Application Reference: 2026/0010

Site Address: 159 Barugh Lane, Barugh Green, Barnsley, S75 1LJ

Introduction: Erection of two storey/single storey rear extension to dwelling (Amended Description)

Drawing No. MPC001 -001
 Rev No.

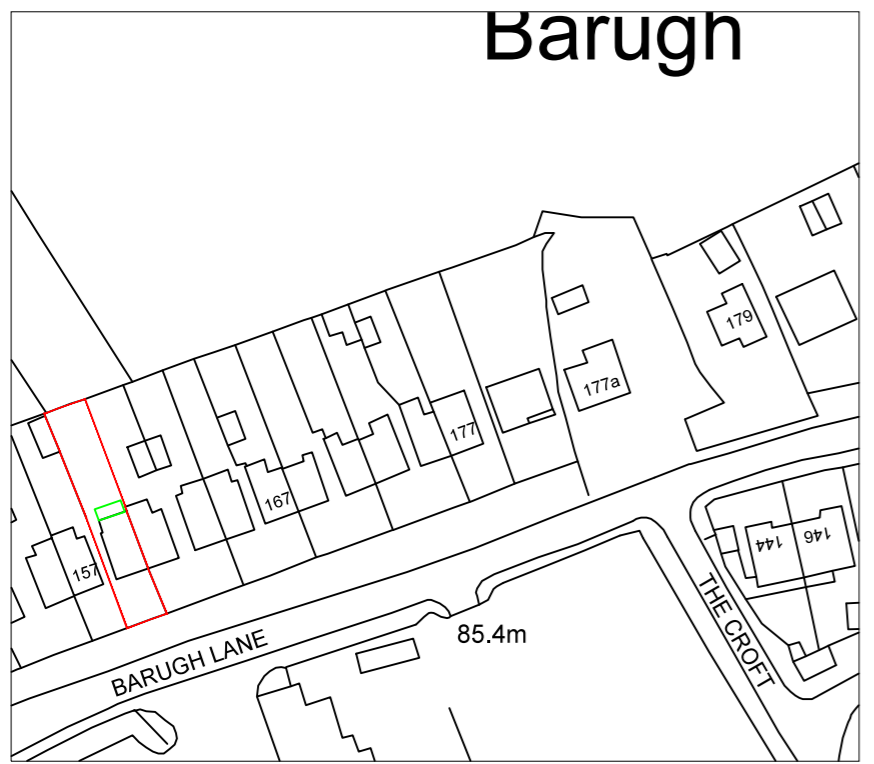
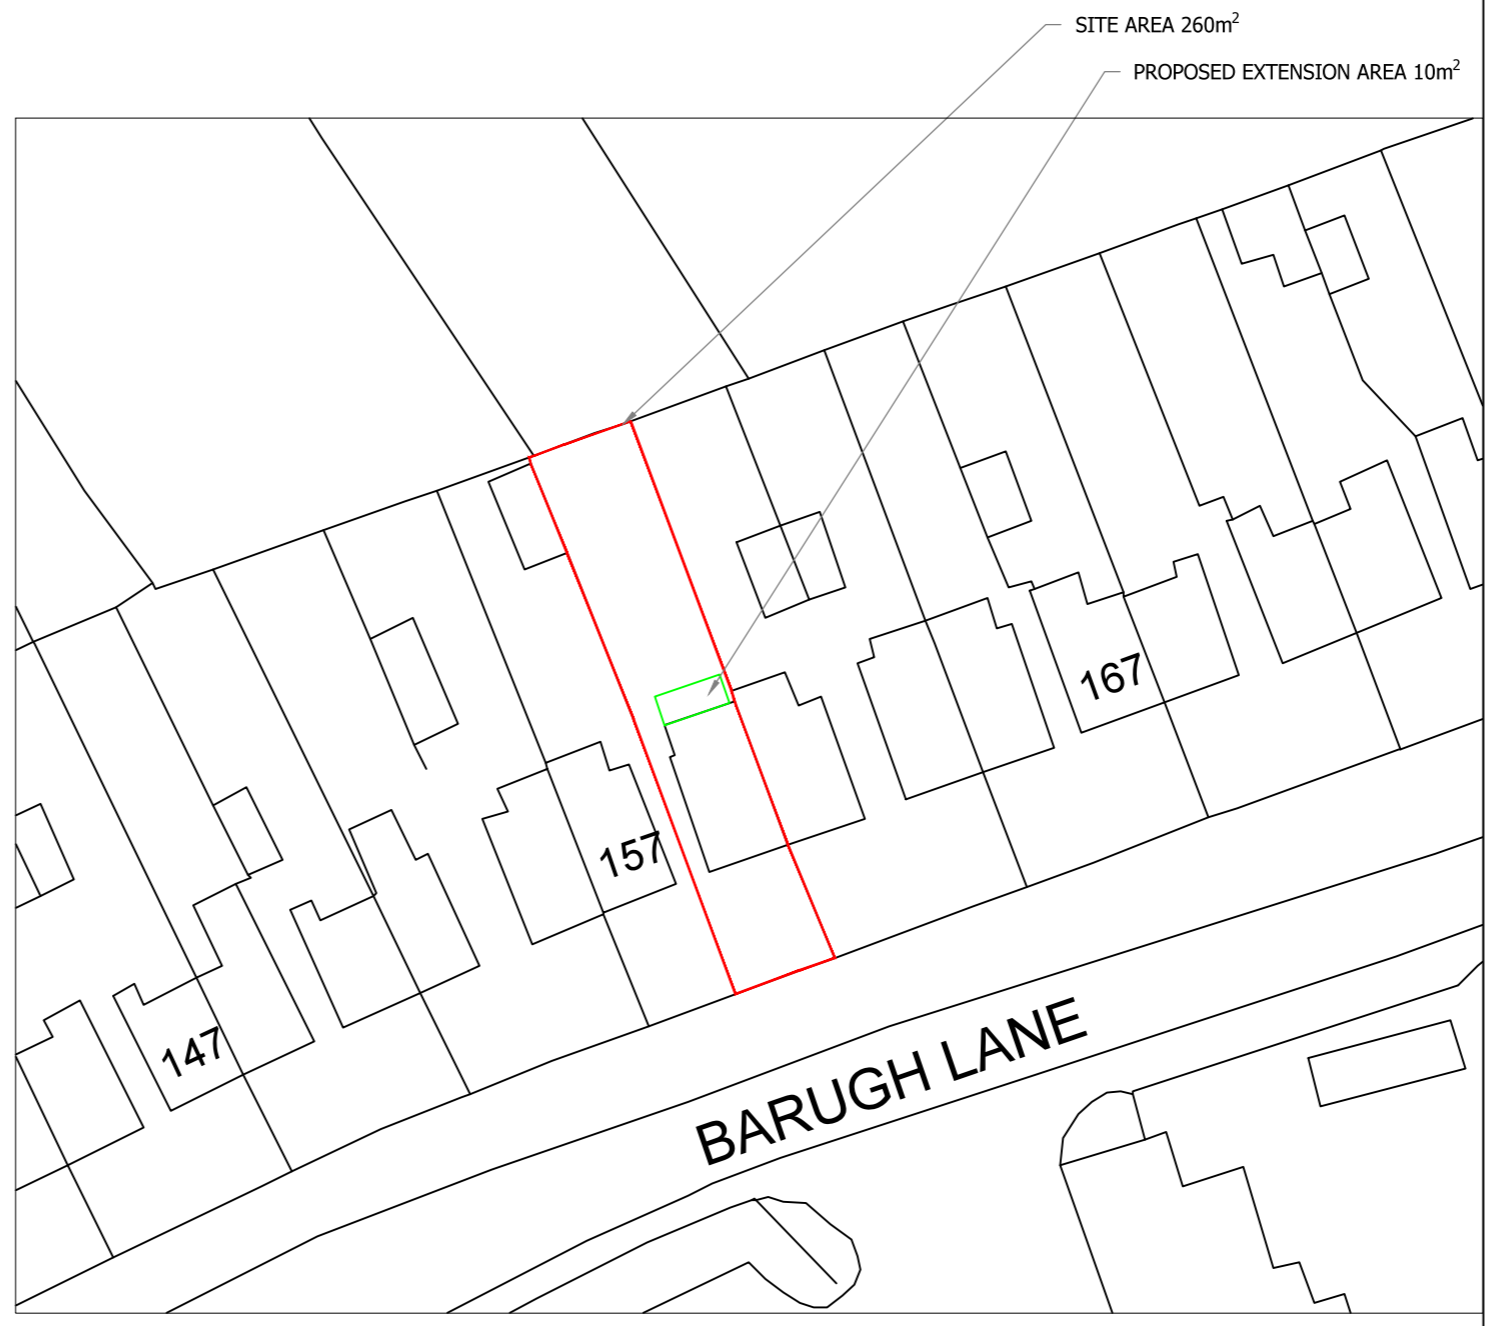
Objections were raised to the original proposal which included the formation of parking facility to the front of the dwelling due to the impact on the character of the street scene and the possible encroachment onto the existing shared driveway. This element of the proposal has since been removed. No objections have been raised to the amended proposal.

It has been necessary to make contact with the applicant in order to remove the initially proposed parking provision to the front of the dwelling which would have resulted in the loss of the front residential amenity space and would have significantly detracted from the character of the street scene. Amendments were received 19th February 2026.

Drawing No.	Rev No.
MPC001 -004

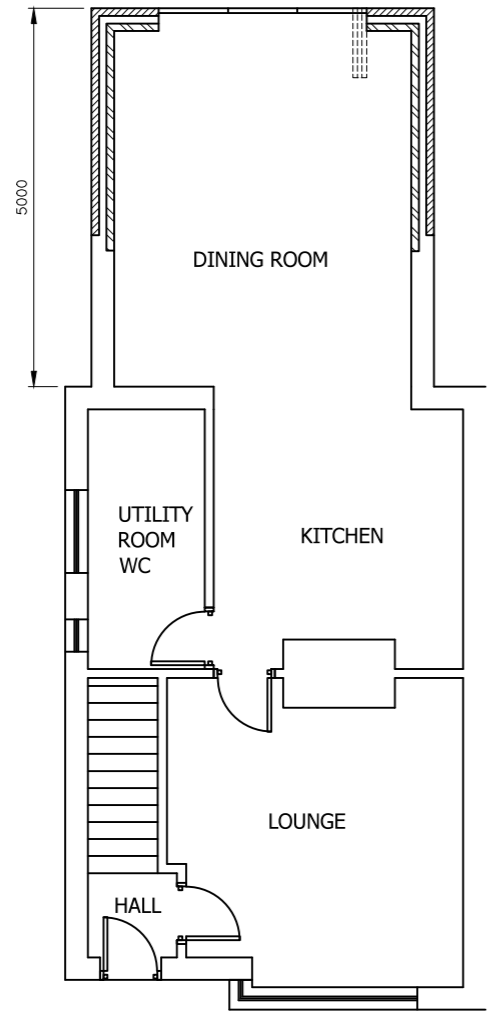
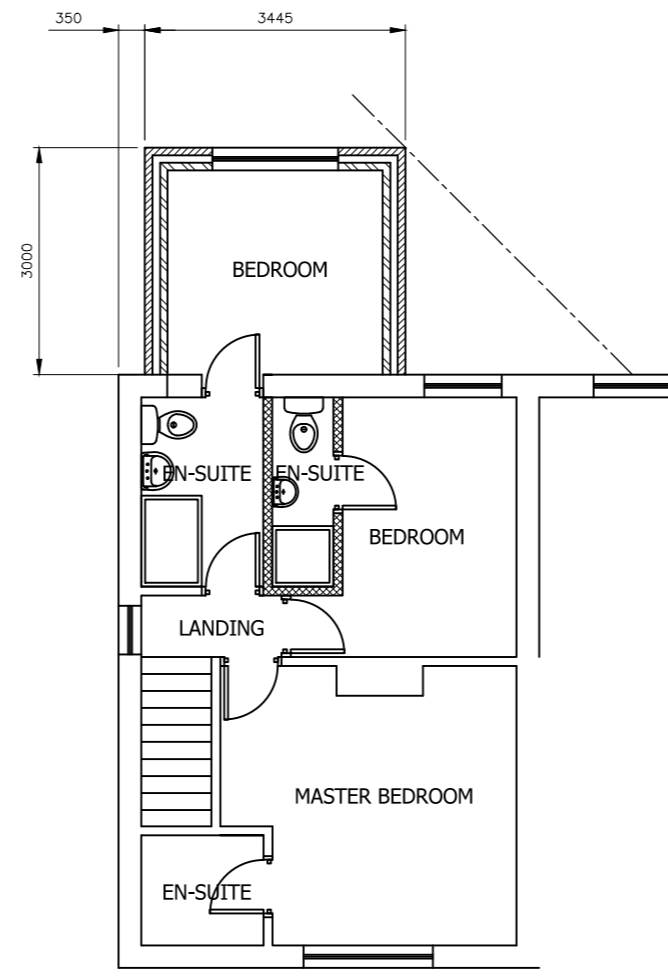
The proposal provides a significant rearward projection at ground floor level. Although single storey extensions are outlined on the house extensions SPD to not exceed 4 metres, given there have been no objections to the proposal, it is accepted that a proposed single storey element could be erected up to 6 metres under permitted development. Furthermore, as outlined above, the SPD allows larger extensions where the neighbouring property has extensions. In this case both the attached and non-attached neighbouring properties have existing extensions, as such, the proposed extension would not project significantly beyond those. Therefore, on this occasion the projection is considered acceptable. Additionally, the proposal benefits from a modest approximate eaves' height of 2 meters and a matching roof type.

Given the proposal would be erected to the west of the adjoined neighbour 161 Barugh Lane, any overshadowing would be restricted to the evenings. It is acknowledged the single storey proposal does provide a significant projection, however given there have been no objections to this element, a proposal with a similar projection could be erected under a prior-notification application. Additionally, the adjoined neighbour has an existing extension projecting approximately 2.5 metres to the rear. The proposed 5 metres projection of the proposal will therefore only project further to the rear of the neighbour by approximately 2.5 metres, reducing the impact of the proposal. The impact of the proposal is also reduced as the extension is set in from the boundary by approximately 0.7 metres and an eaves height of approximately 2 metres is detailed.

Drawing No. MPC001 -003 Rev No.

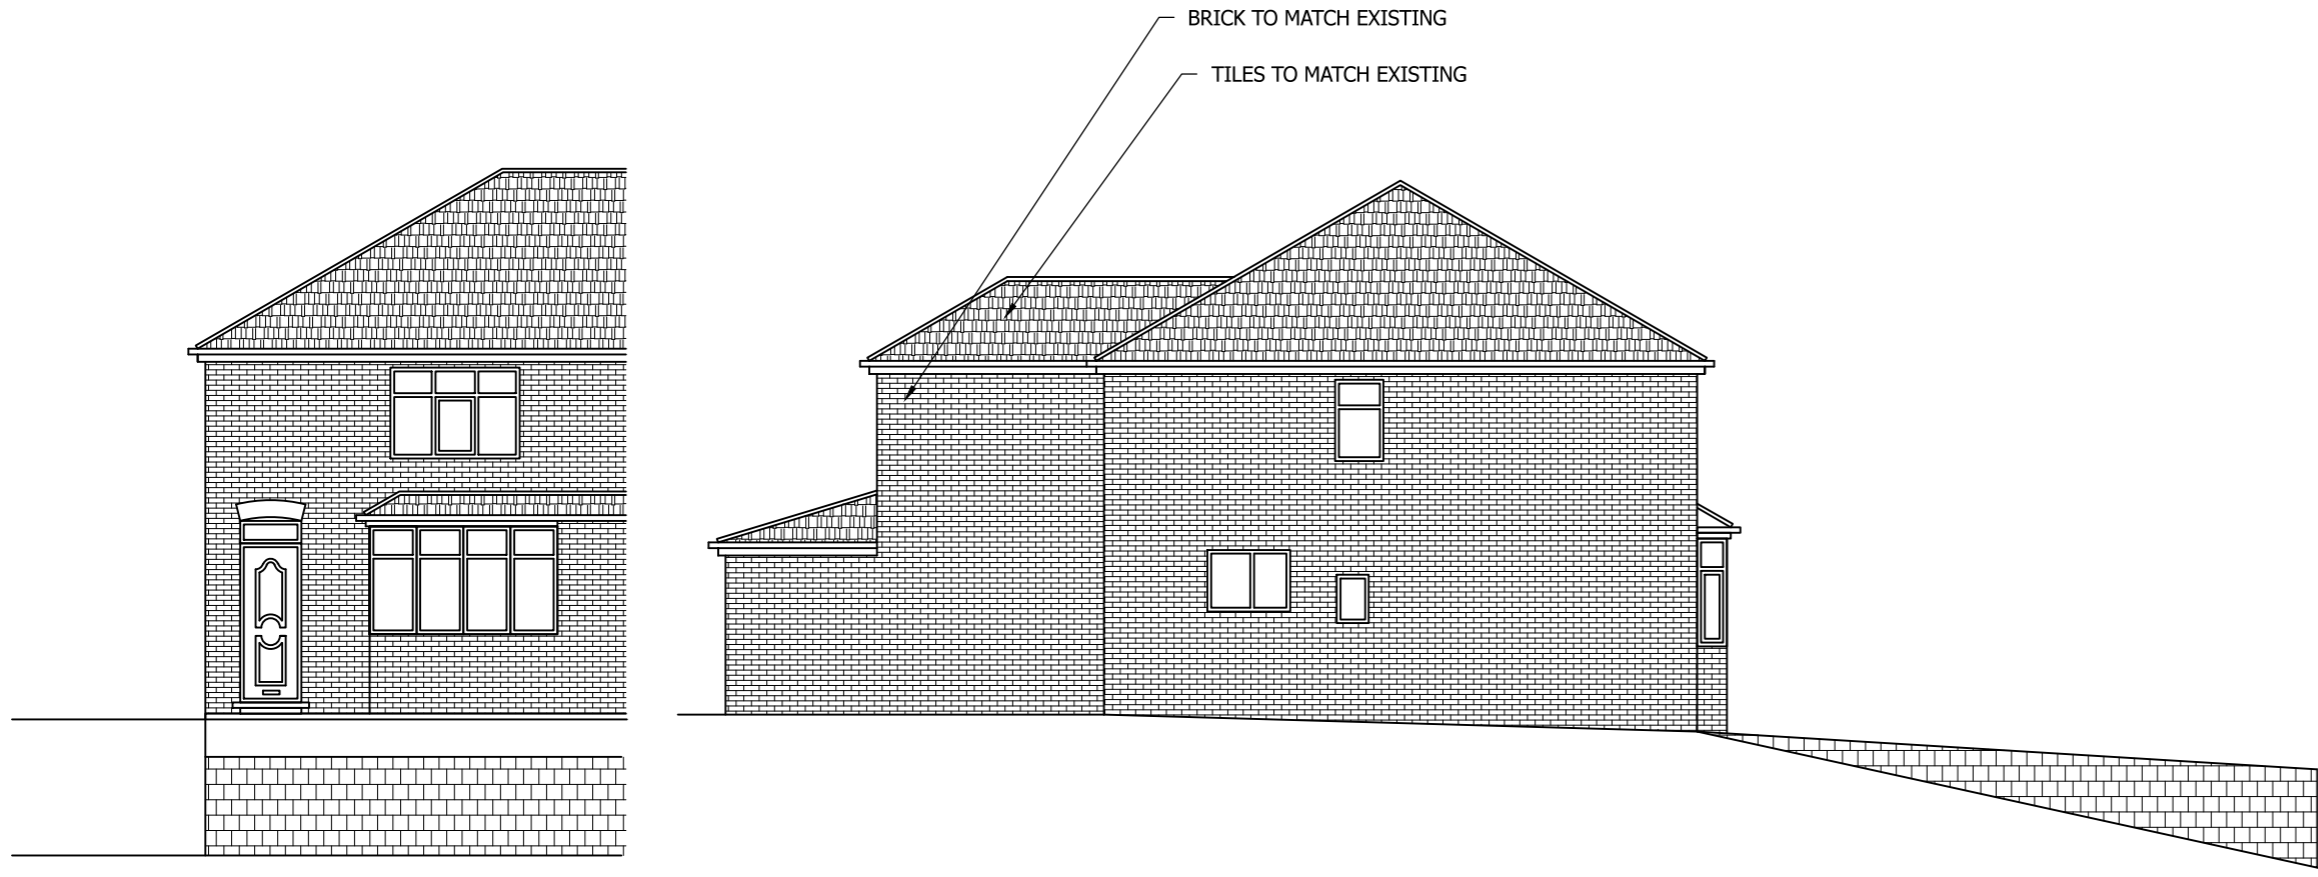
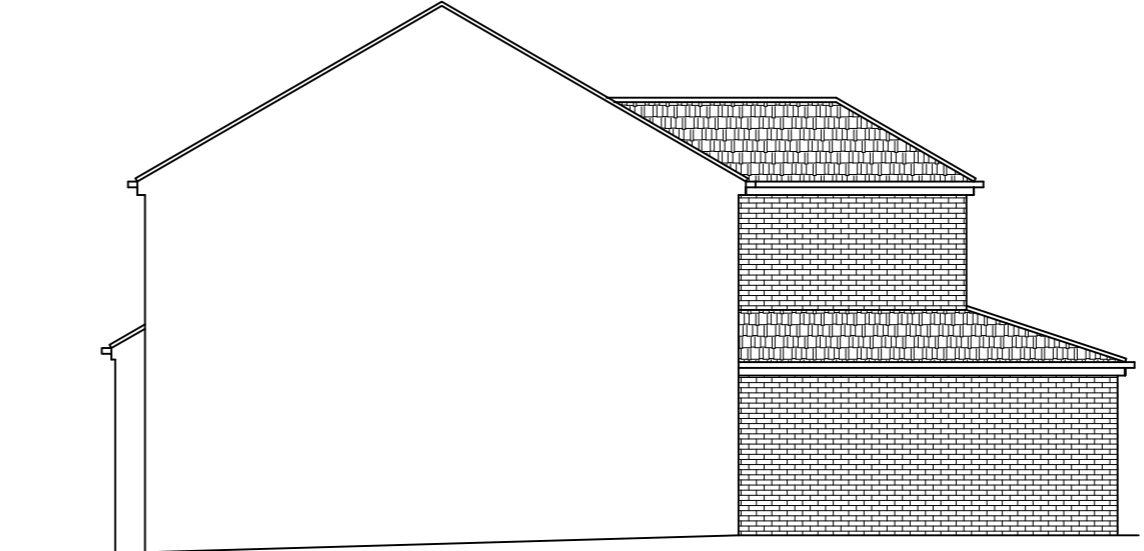
The proposed two storey extension provides an acceptable rearward projection of approximately 3 metres when assessed against the House Extensions SPD. The extension is set in from the adjoined neighbouring property by approximately 1.6 metres and set down from the ridge by approximately 1.3 metres allowing the proposal to remain subordinate to the existing dwelling. The use of a hipped roof form and matching materials allows the proposal to remain in keeping with the character of the dwelling.

The proposed glazing has been detailed centrally to their respective extensions and provide similar fenestration to the existing glazing.

The proposed two storey extension has been set in from the adjoined neighbour by approximately 1.6 metres. The proposal also provides a modest rearward projection of 3 metres which is 0.5 metres less than the 3.5 metres outlined within the House Extensions SPD. This prevents the two-storey extension from intersecting the 45-degree angle of the neighbouring rear window, preventing any overbearing nature or detrimental loss of light.

Bifold doors are proposed to the ground floor. Although the glazing is extensive, it is not considered to provide opportunity for overlooking directly to neighbour amenity space. The first-floor window servicing a bedroom would allow for views to the rear of the property, however the proposal has been set away from the neighbouring boundary and faces the rear amenity space of the site.
